MECKLENBURG COUNTY  
Park and Recreation Department

MEMORANDUM

**RE:** Rezoning Petition #2023-162  
PID# 18312111

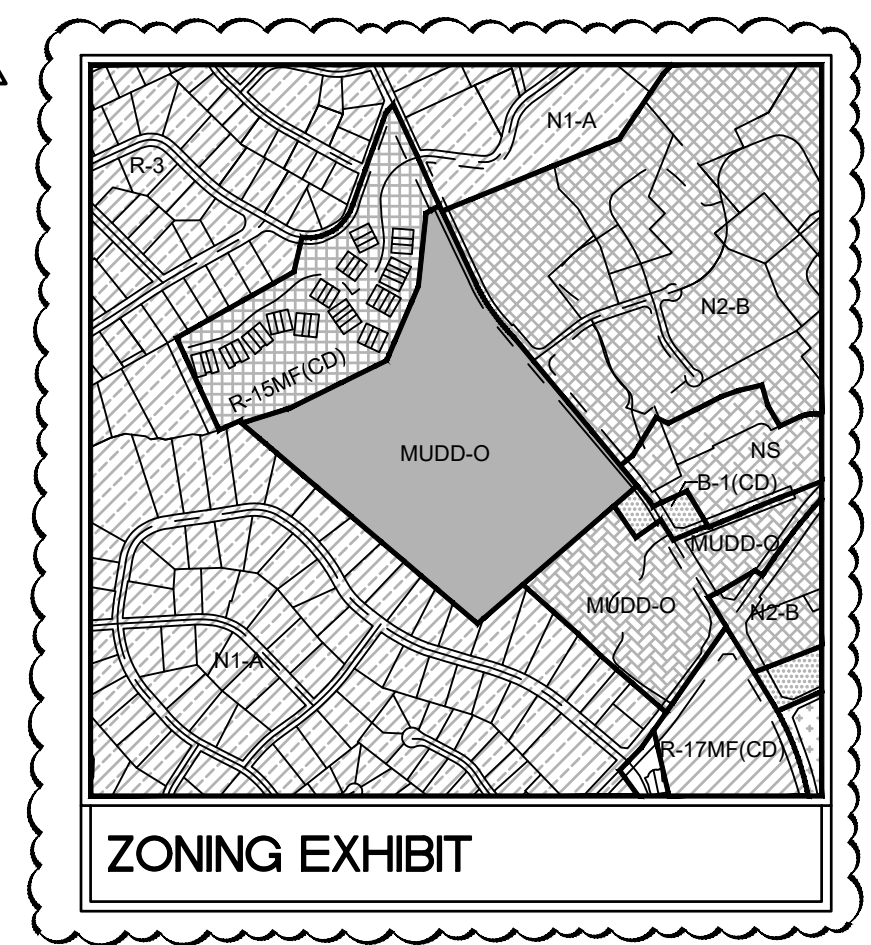
To clarify the previous comments on the revised plans, Mecklenburg County requests a vehicular access easement from Providence Road to the 100' Greenway Easement along the private development streets.
